# COUNTY COUNCIL'S RESPONSE TO CONSULTATION ON THE FOLLOWING DEVELOPMENT PROPOSAL

**Application No:** 20/01747/F

**Proposal:** Change of Use of land to a 6no pitch Gypsy and Traveller site to include 6no mobiles, 6no tourers and associated operational development including hardstanding and fencing

**Location:** Land South Side Of Widnell Lane Piddington

# Proposed Block Plan

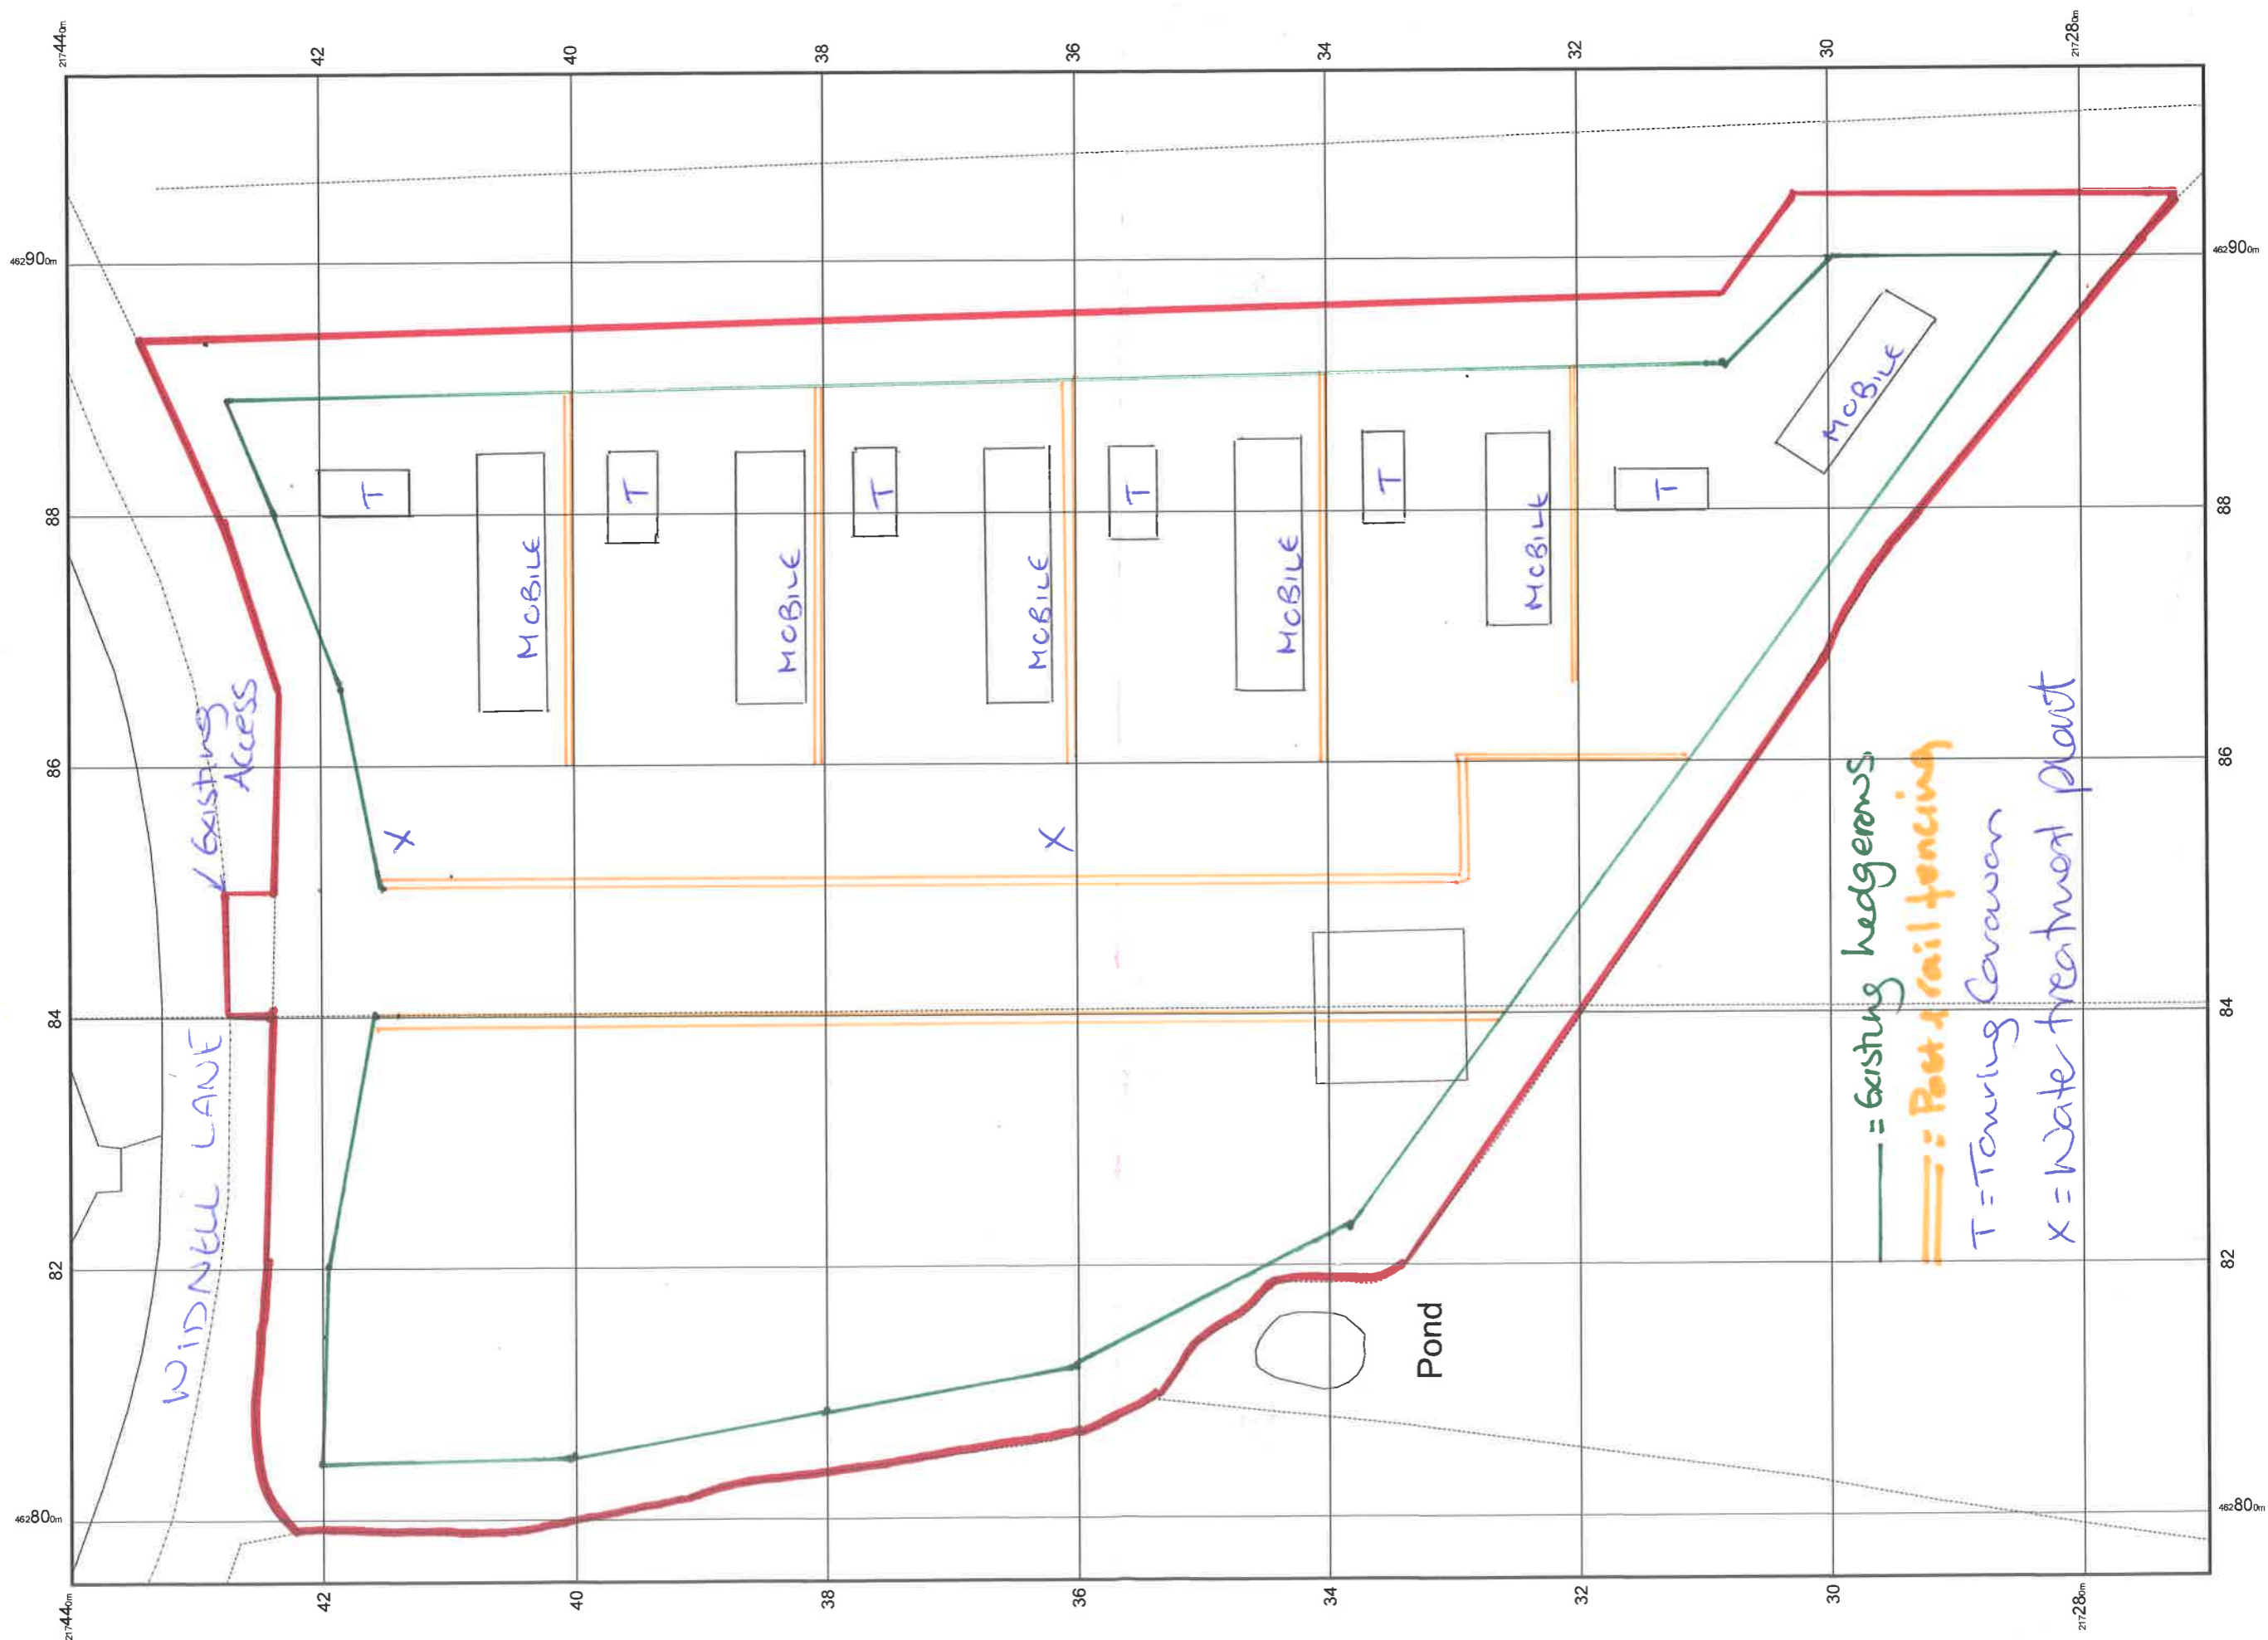
The Proposed Block Plan labels the access point from Widnell Lane as “Existing Access”, although none was evident when I made my site visit. I am happy that the visibility is at least as good as that available from the approved and partly constructed access to the adjacent field. As the application site is closer to the B4011 junction, it is likely that speeds in both directions will be slightly less, so the proposed access location is acceptable.

Any gates would need to be set back sufficiently to ensure that vehicles and trailers do not have to wait on the carriageway whilst gates are opened.

A bellmouth junction would need to be provided and this will require a S278 agreement with OCC to carry out the works on the highway.

By reference to the OCC response to the adjacent site, I note that a full-size (11.6m long) refuse collection vehicle (RCV) will be expected to enter the site. The layout must be designed to allow the RCV to enter, turn in and exit the site safely in a forward gear. The Inspector for the appeal did not require a condition to demonstrate that these manoeuvres were possible, so I have not requested such a condition in the event of permission being granted.

Prior to commencement of the development full details of the site access bellmouth junction shall be submitted to and approved in writing by the Local Planning Authority. There shall be no occupation of the site until the site access junction has been constructed in accordance with the approved details.

Prior to commencement of the development, full details of the internal road and turning area including swept path analysis showing that an 11.6m long refuse collection vehicle can enter and leave the site in forward gear, shall be submitted to and approved in writing by the Local Planning Authority. There shall be no occupation of the site until the internal road and turning area have been constructed in accordance with the approved details.
